Addendum No. 1

RE: Contract ID C202582

Transylvania County (R-2409C)

US-64 From Lake Toxaway To Indian Creek

ROCK FILL DETAIL

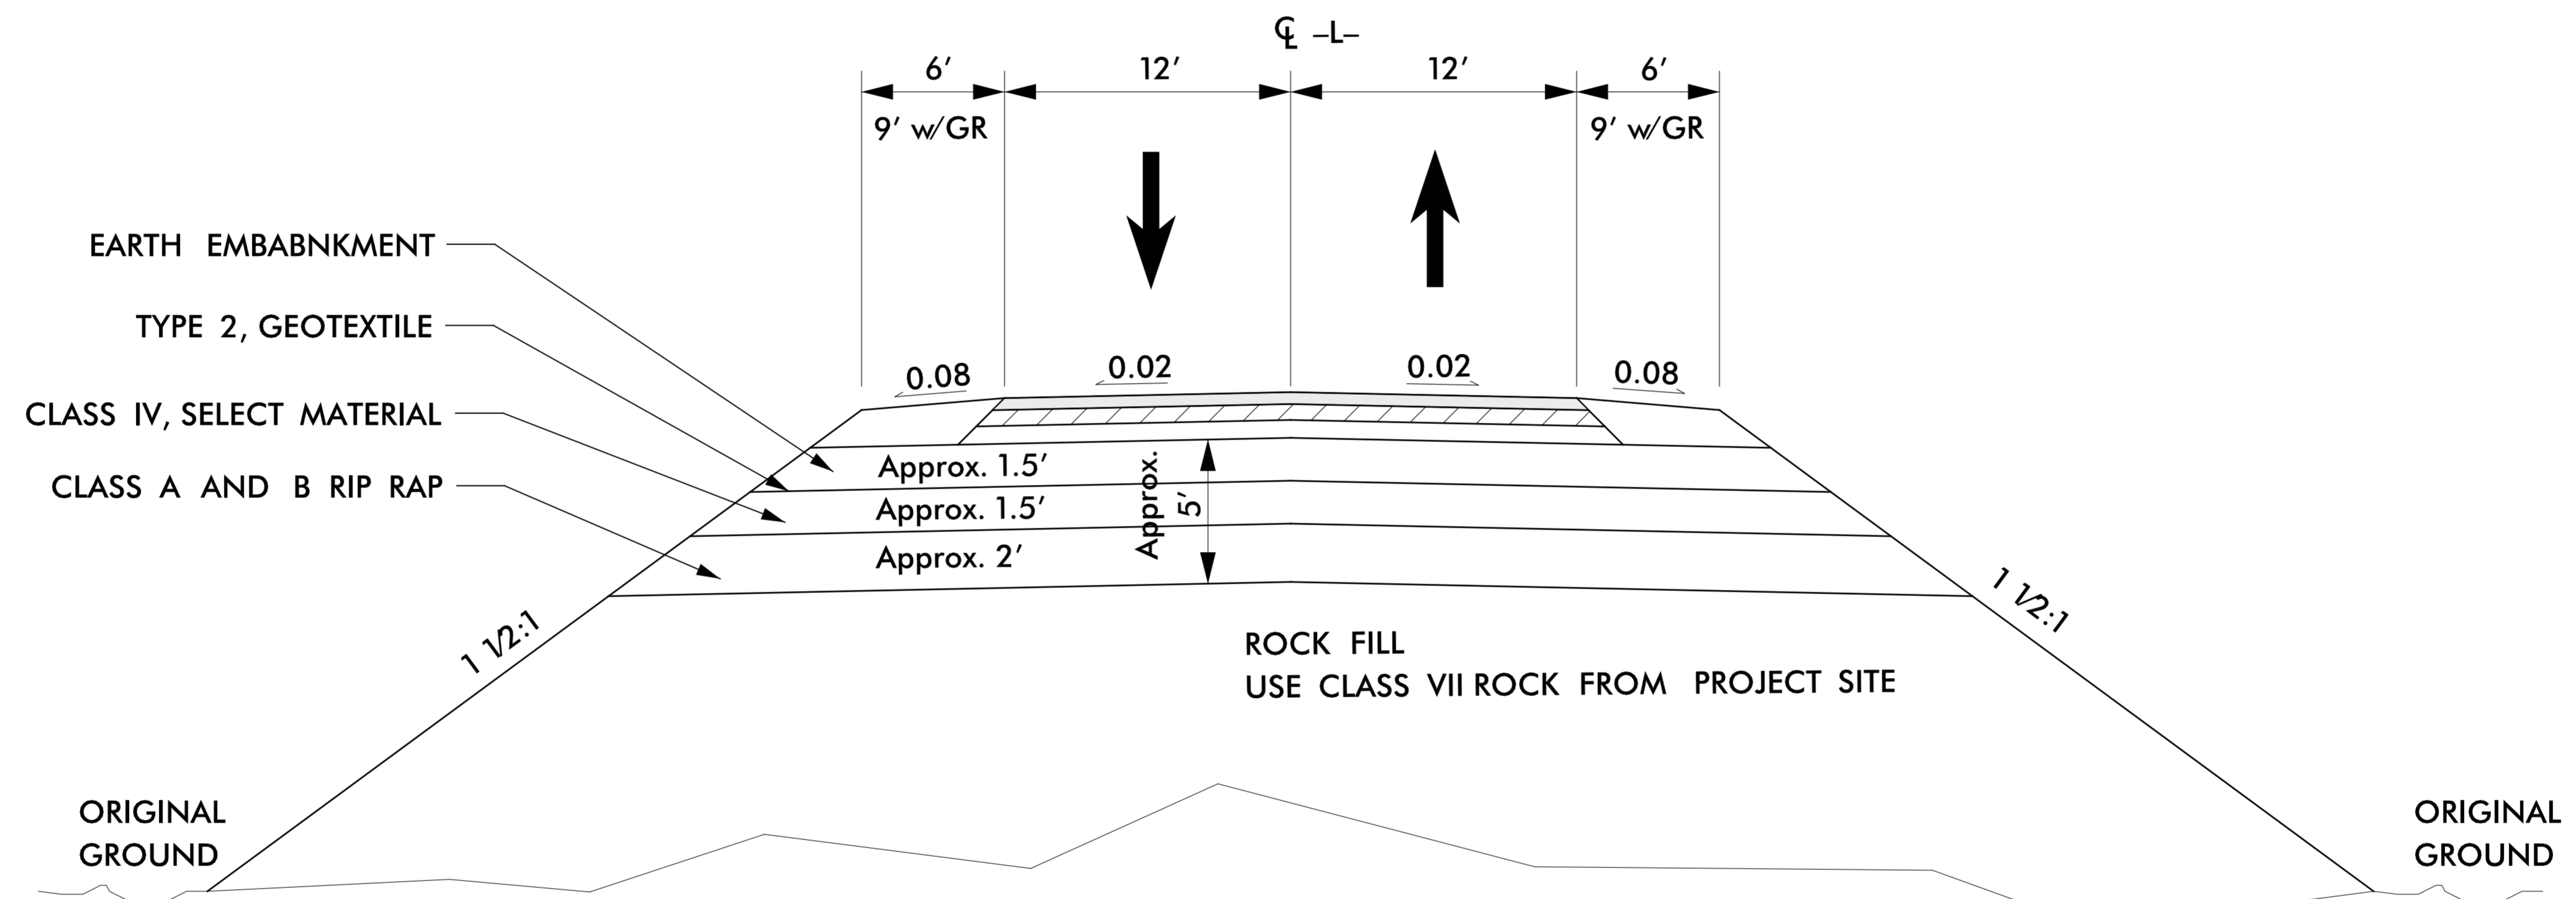
Sheet No.	Revisions
2B-3	Revised "Rock Embankments" detail to correct the Class of "Select Material" and added "Summary of Pre-Splitting Rock"
